Re: Approval of Permanent Certificate of Occupancy (C.O.) for
Heflin Dental Clinic, [C-19 / D45]
8000 Carmel Ave. NE
Architect's Stamp Dated 08/14/06

**Re: Heflin Dentist Office, Carmel Avenue NE, Traffic Circulation Layout
Engineer's Stamp dated 12-21-04 (C19-D45)**

Based upon the information provided in your submittal received 12-21-04, the above referenced plan cannot be approved for Building Permit until the following comments are addressed:

ARCHITECTURAL SITE PLAN FOR BUILDING PERMIT

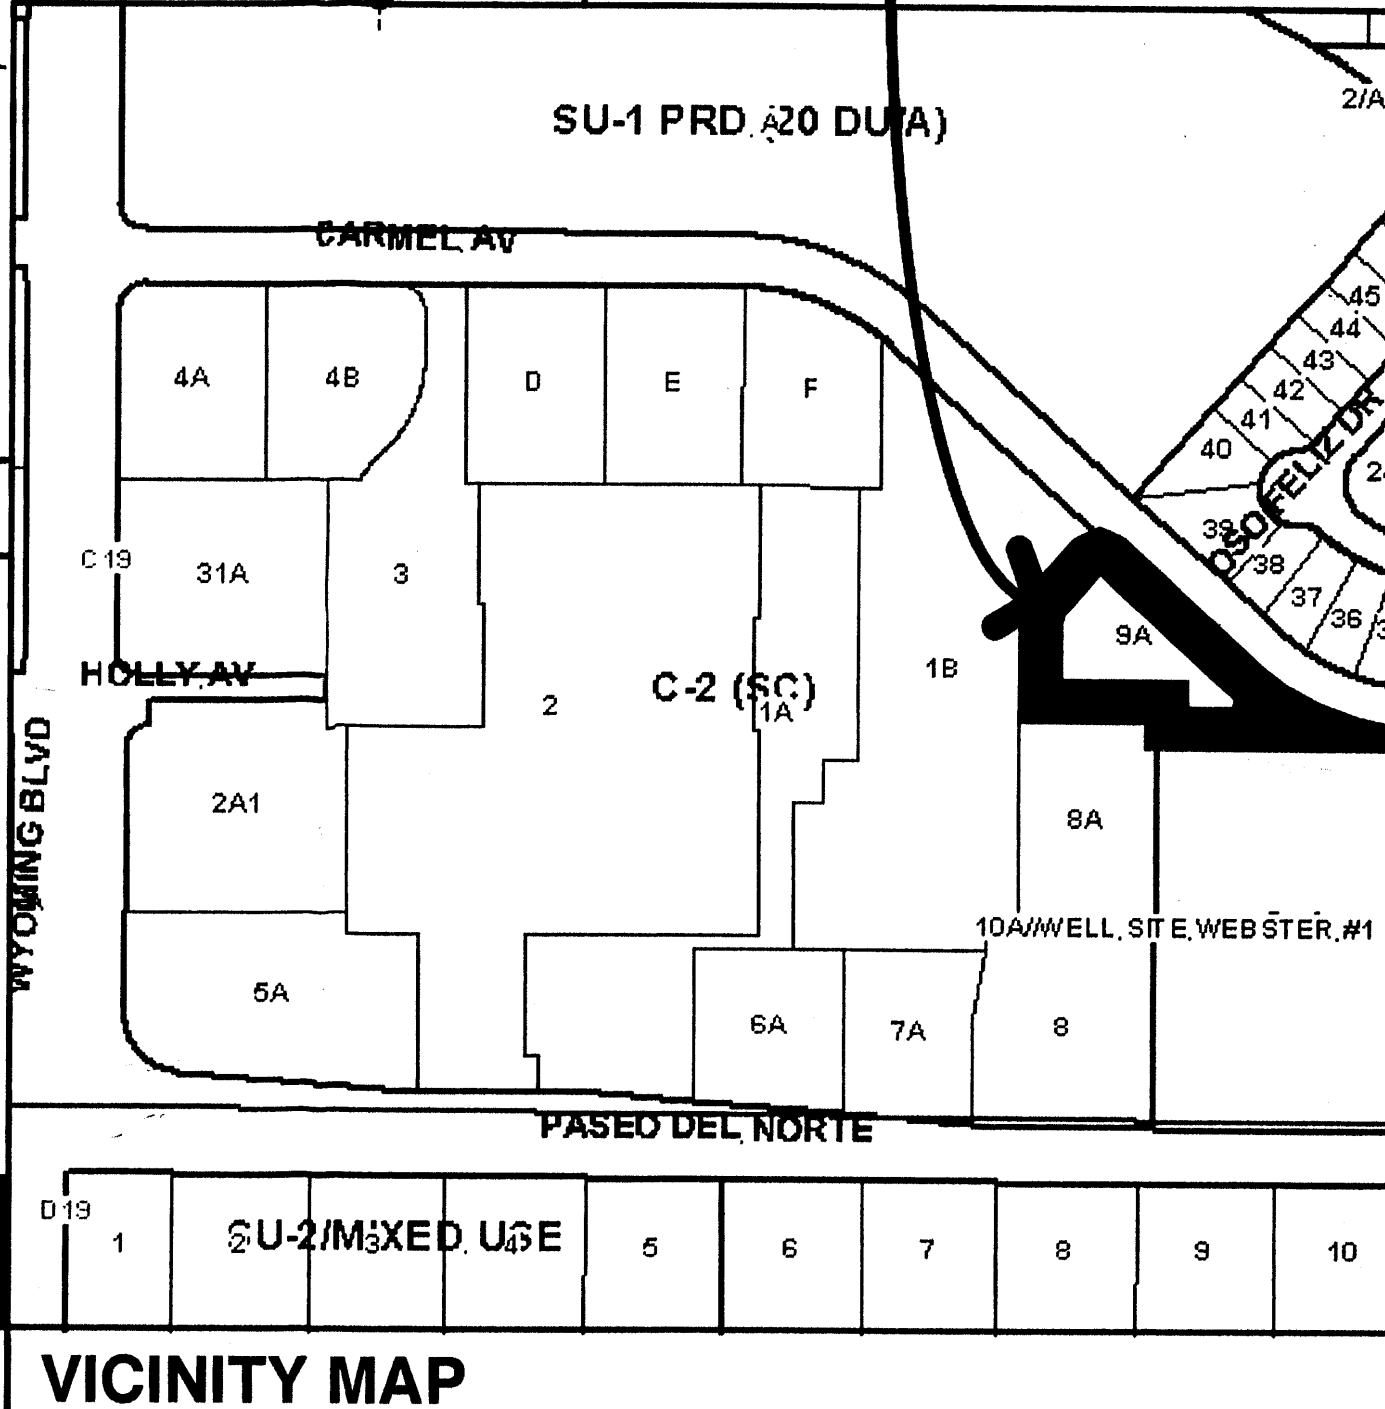
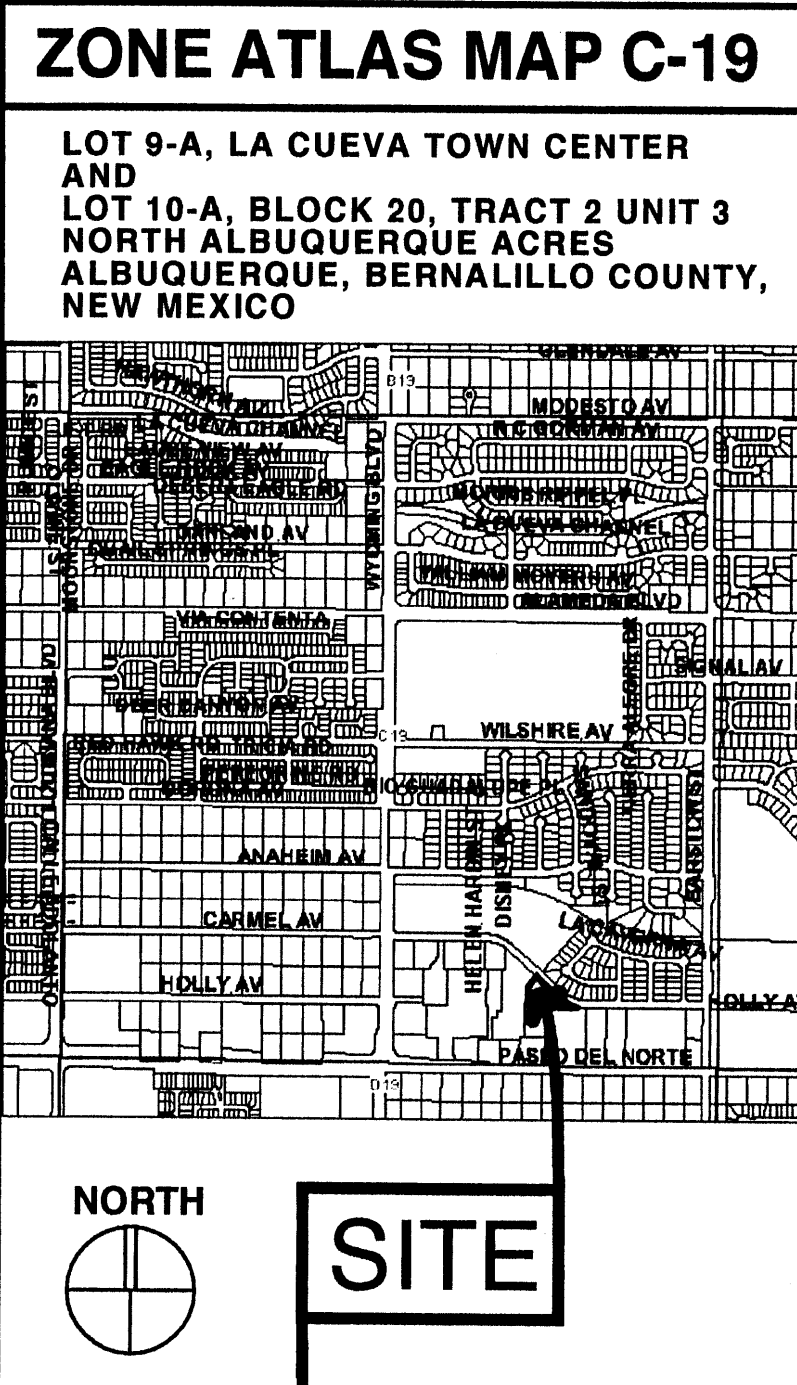
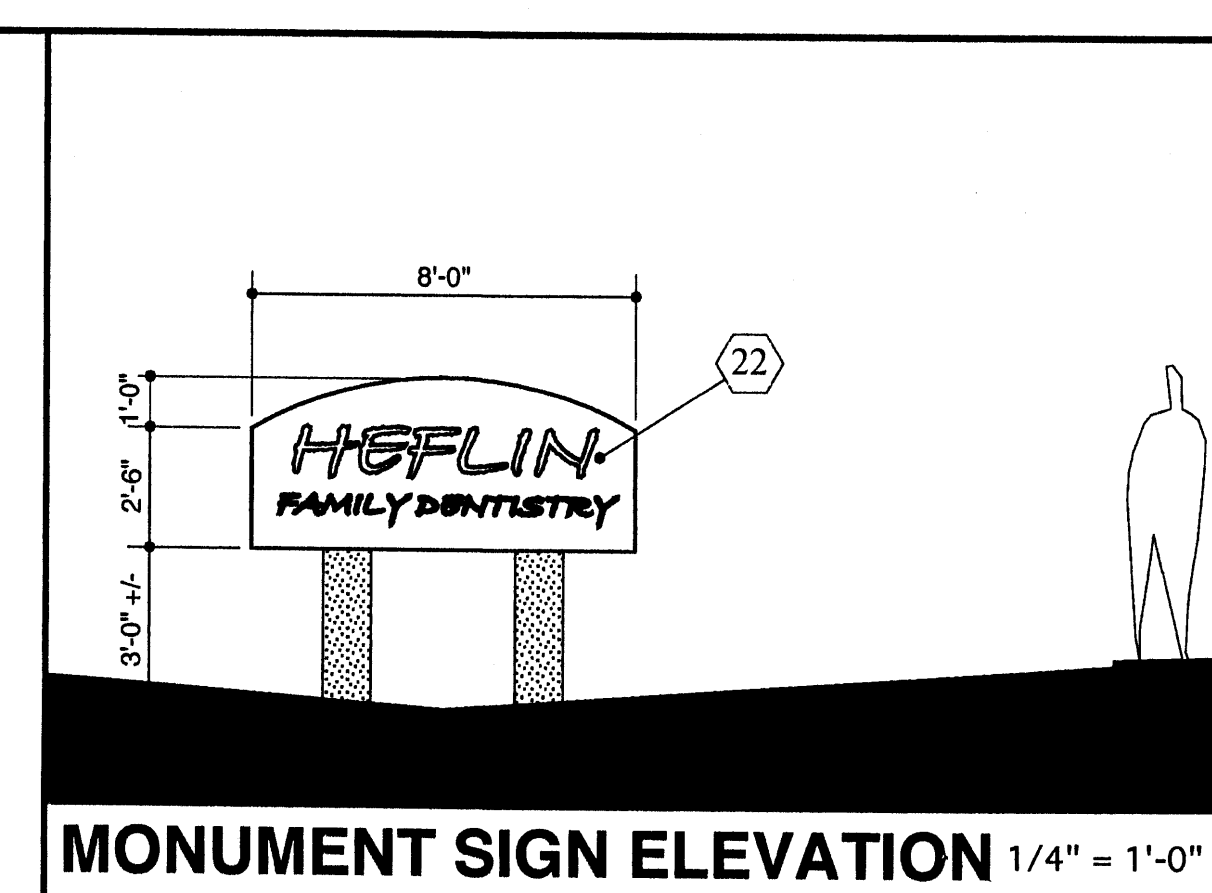
1. Please include two copies of the traffic circulation layout at the next submittal.
2. List the number of parking spaces required by the zoning code as well as the proposed number of parking spaces.
3. Please list the length for all parking spaces.
4. For passenger vehicles, the minimum end island radius is 15 feet.
5. A five-foot keyway is required for deadend parking aisles.
6. Provide a separate traffic circulation layout.
7. Call out the aisle width each time the layout changes.
8. Please show a vicinity map.
9. Is the drive shown new or existing?
